Development: Fell 1 No Horse Chestnut tree

Location: 17 Walnut Avenue Rustington BN16 3NY

Please ask for: Nicola Moore
Email: nicola.moore@arun.gov.uk
Telephone: Ext 37944
Our Ref: R/169/21/T
Your Ref:
Date: 8th July 2021

Application for Works to Trees(s) subject to a Tree Preservation Order(TPO)

HORSE CHESTNUT (1)

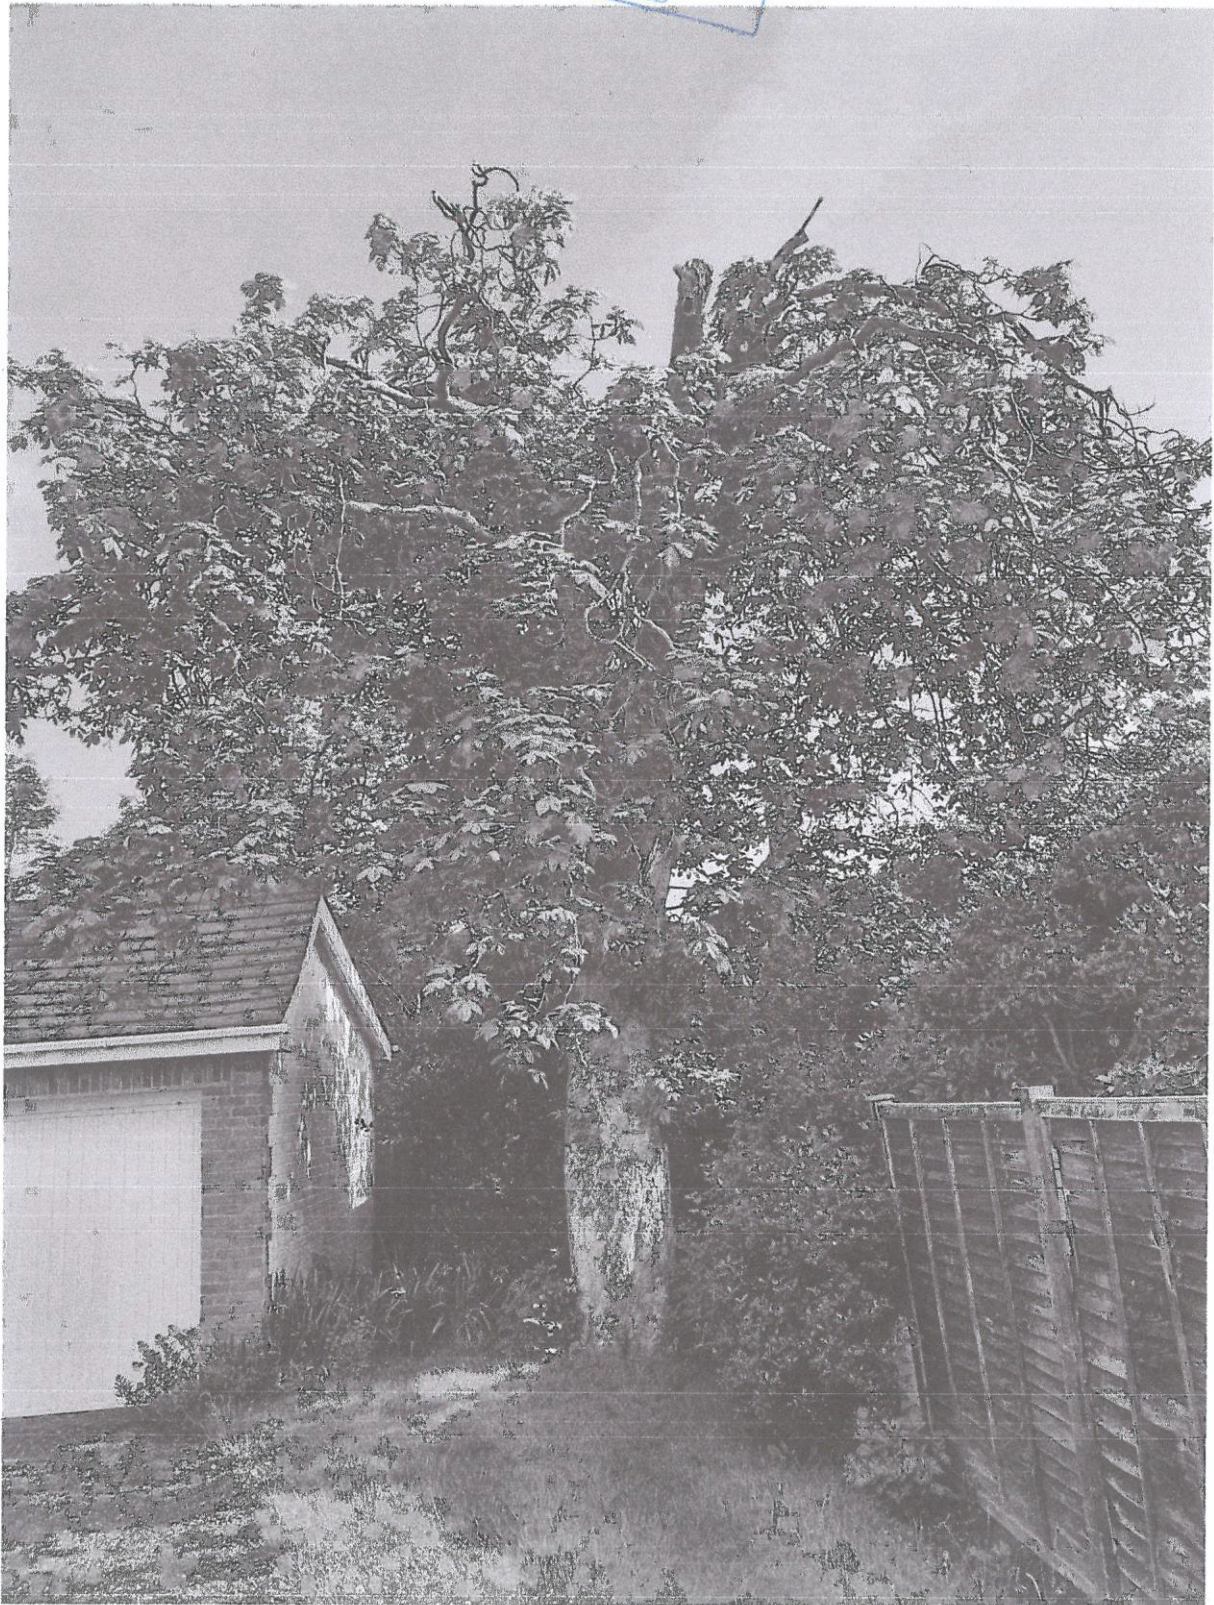
The sketch plan should include road names and adjoining properties. A north point is helpful. Please amend accordingly and re submit.

In response to your request. Please find a sketch plan of road names and adjoining properties below.
